From: [Chad Bala](#)
To: [Rachael Stevie \(CD\)](#); [Jeremy Johnston](#)
Cc: [Dan Carlson](#); [Pat Deneen](#); [Mike Jones](#); [Steve Lathrop](#)
Subject: Bull Ranch Plat, File No. LP-21-00001
Date: Wednesday, April 21, 2021 12:45:13 PM

My name is Chad Bala, and I would like to thank you for the opportunity to comment on the Bull Ranch Plat project (LP-21-00001).

STEVE LATHROP
THE BULL RANCH
 PRELIMINARY SITE PLAN
 KITTITAS COUNTY WASHINGTON

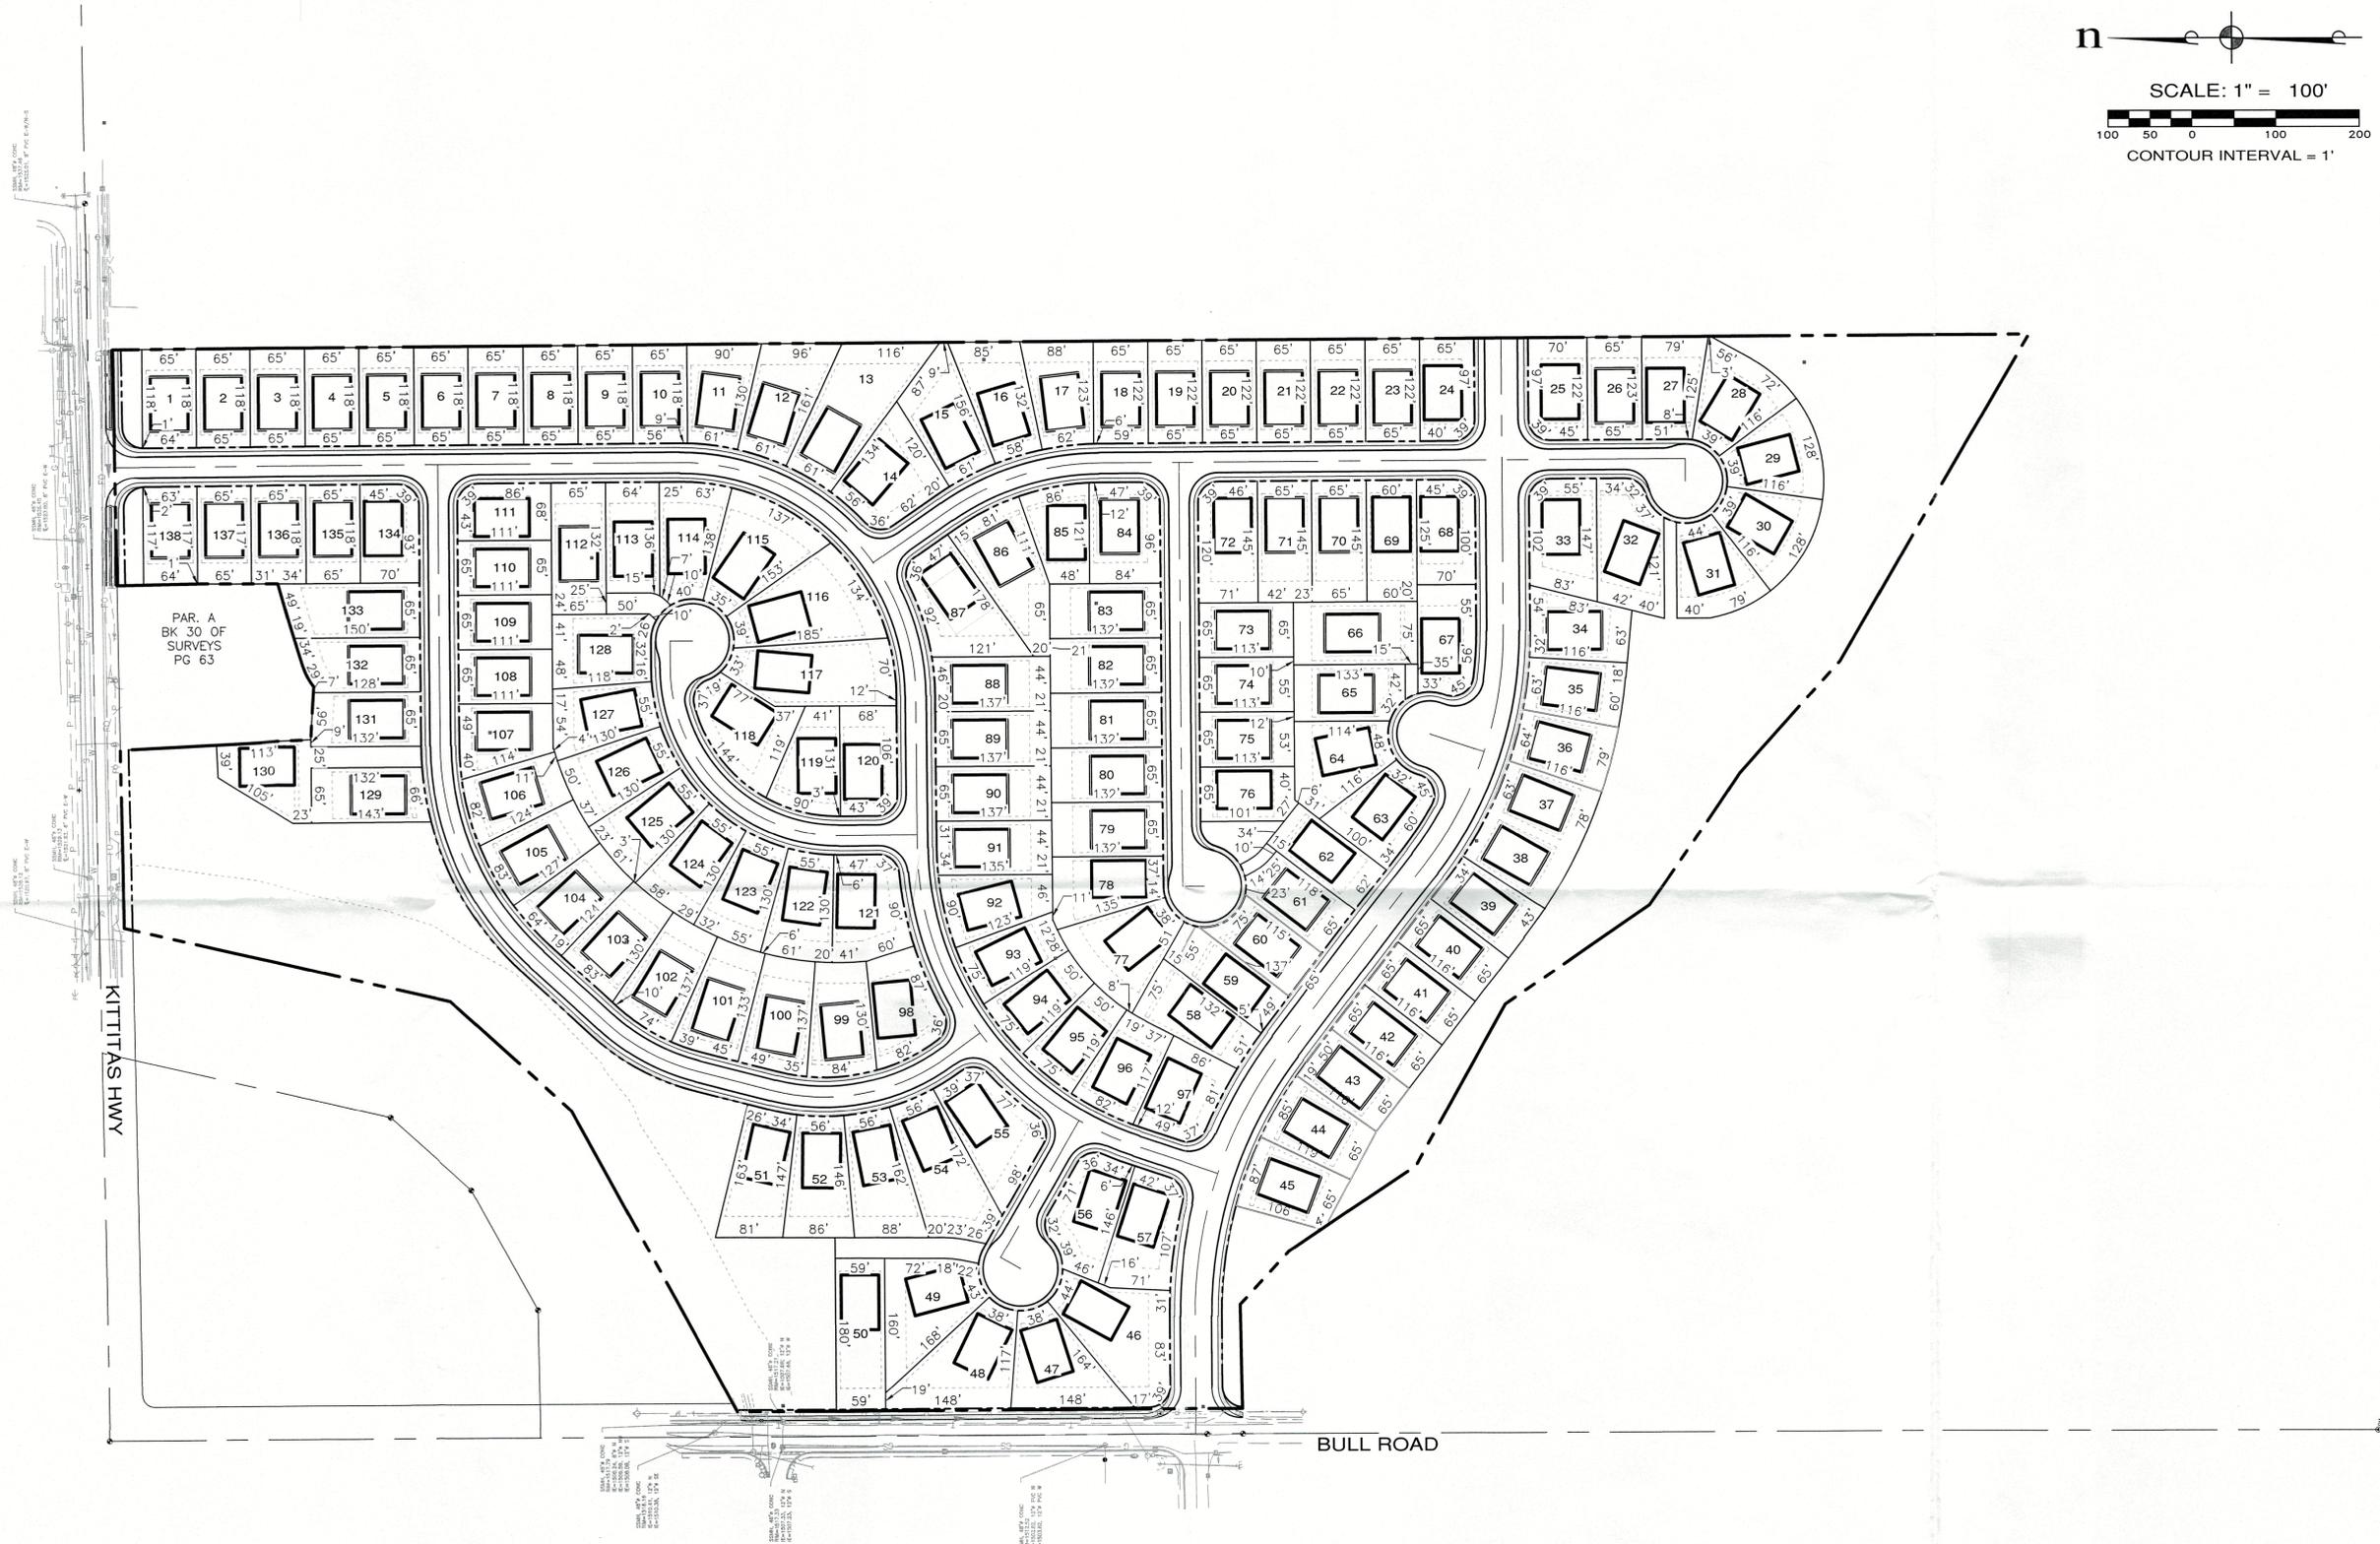
Proposed Road A (Major Collector) is adjacent to our northern property boundary. We would be willing to work with the applicant to see if possible whether or not a joint access could be considered. This access would not only serve this proposed development, but also serve as a future access point to the adjacent property to the South.

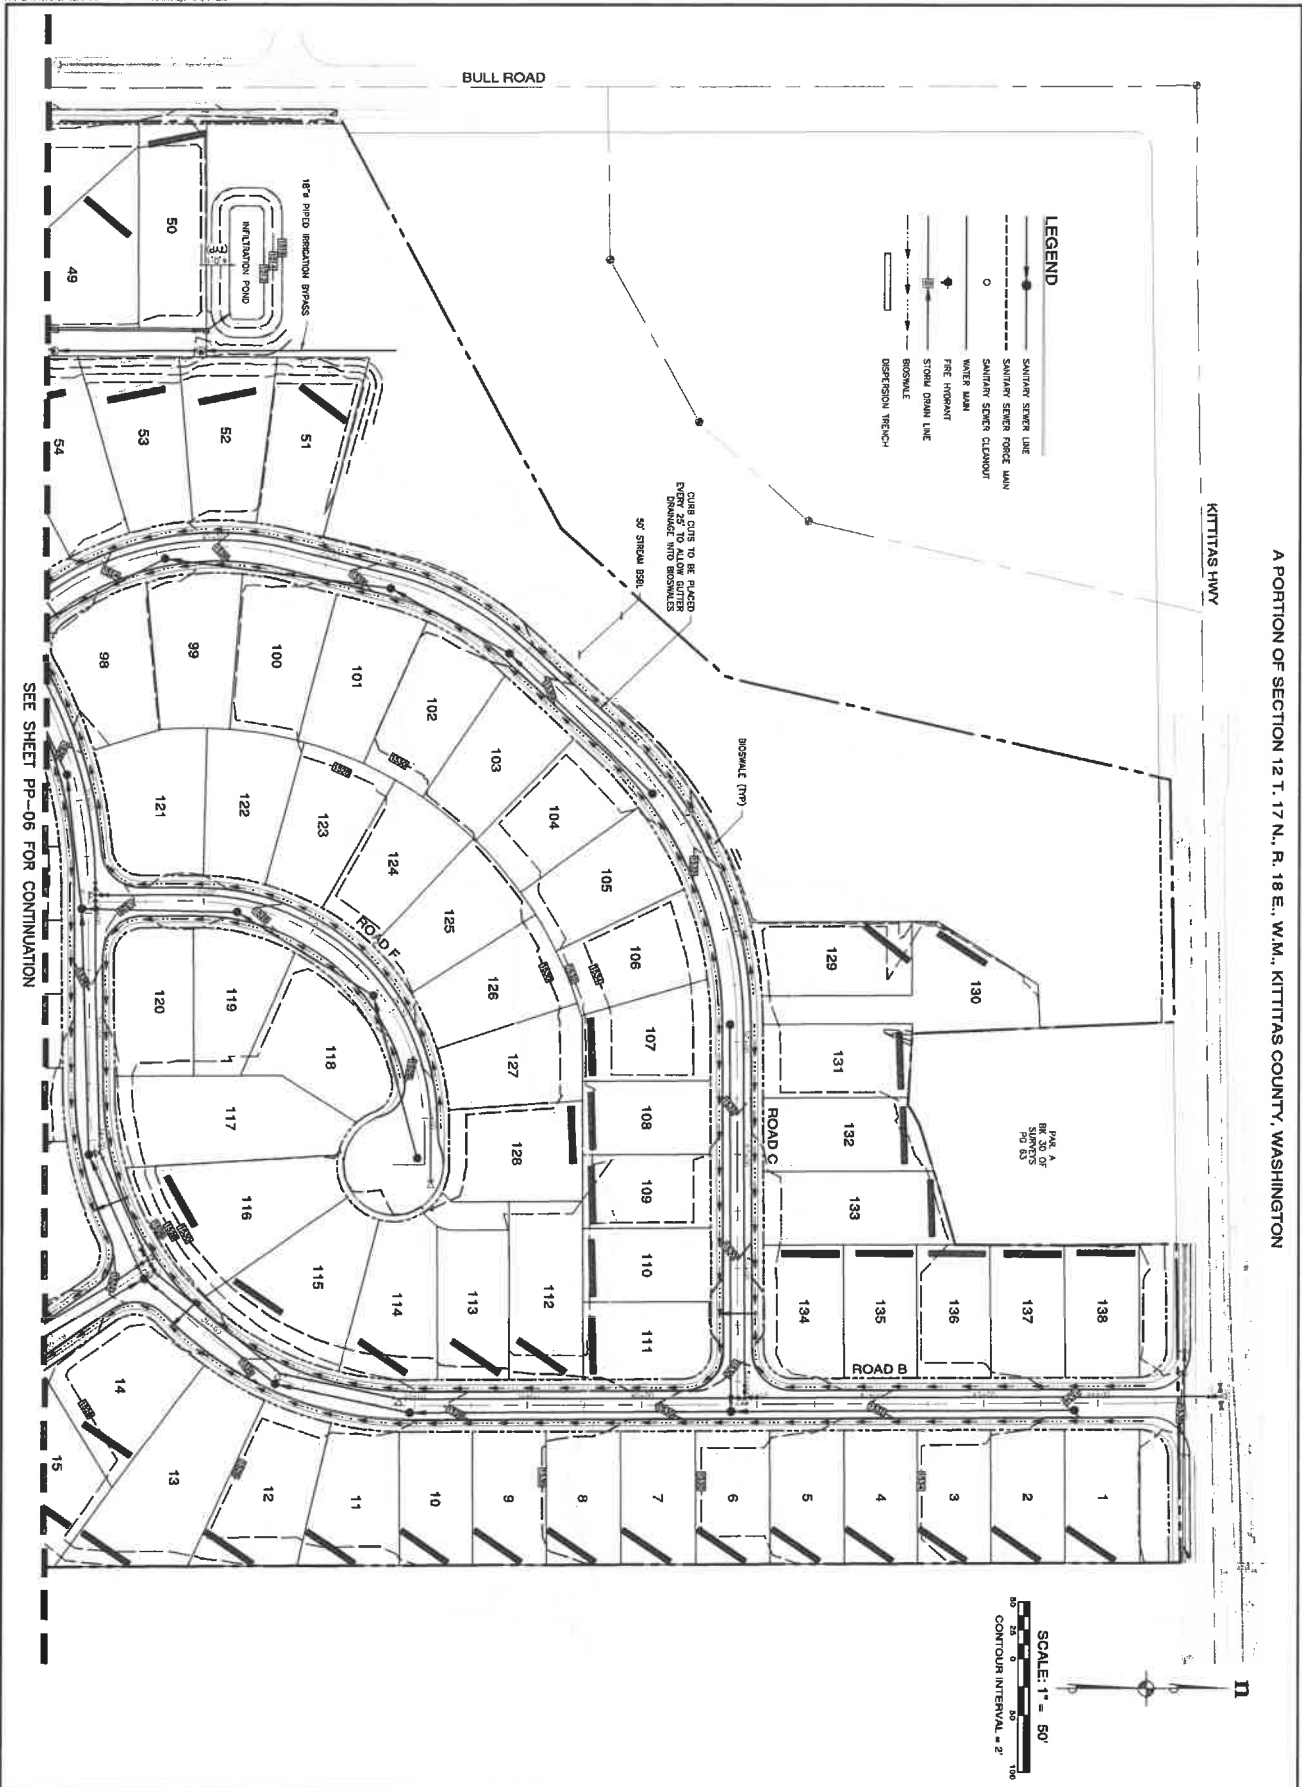
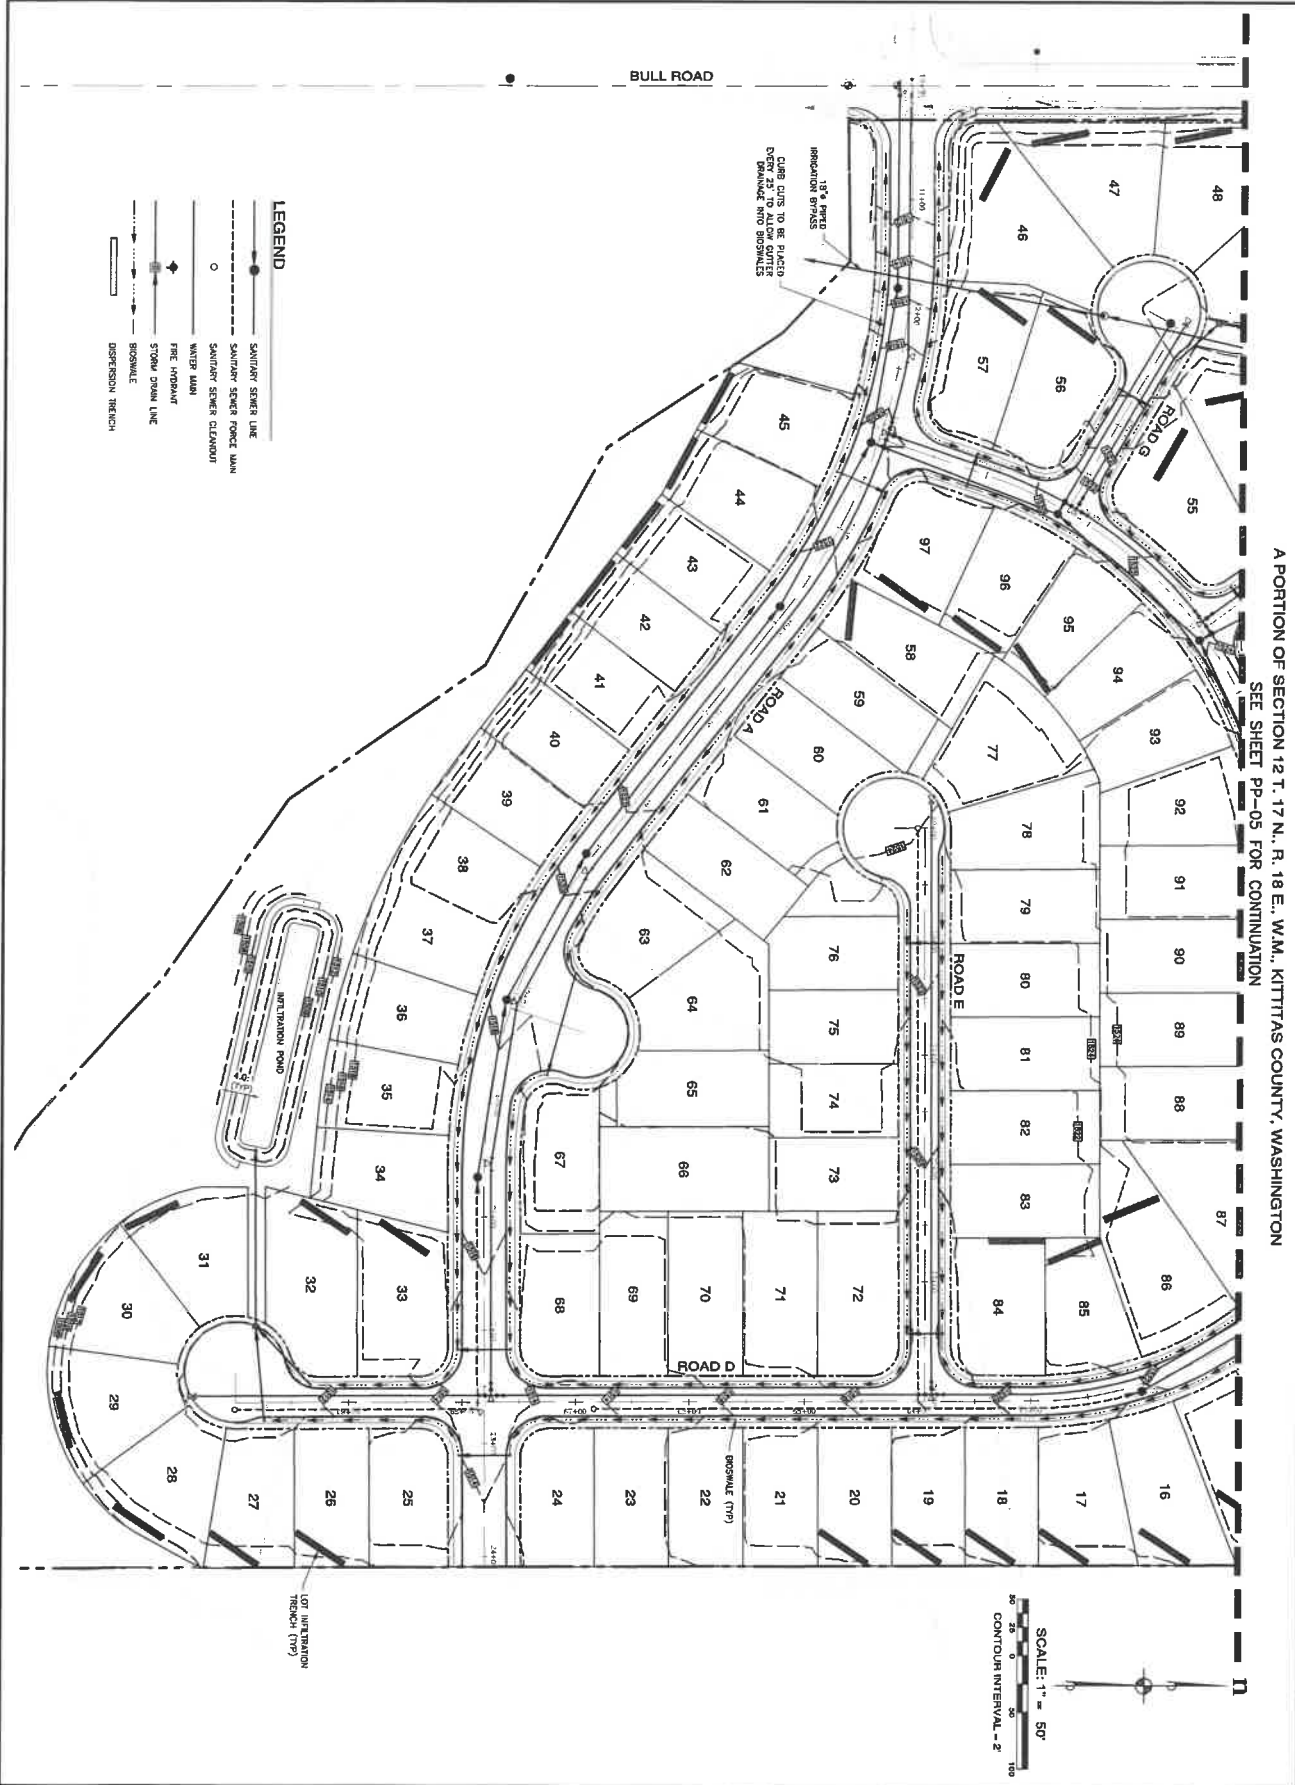
The proposal seems to reflect two stormwater ponds to serve the 138 lot development. Pond 2, which seems to be the larger of the ponds, sits directly behind proposed lots 31 thru 37. Our concern is that Pond 2 is directly above our property to the South (in elevation) and we are not sure of the unintended consequences that this pond can have on our property to the South due to the topography within this area.
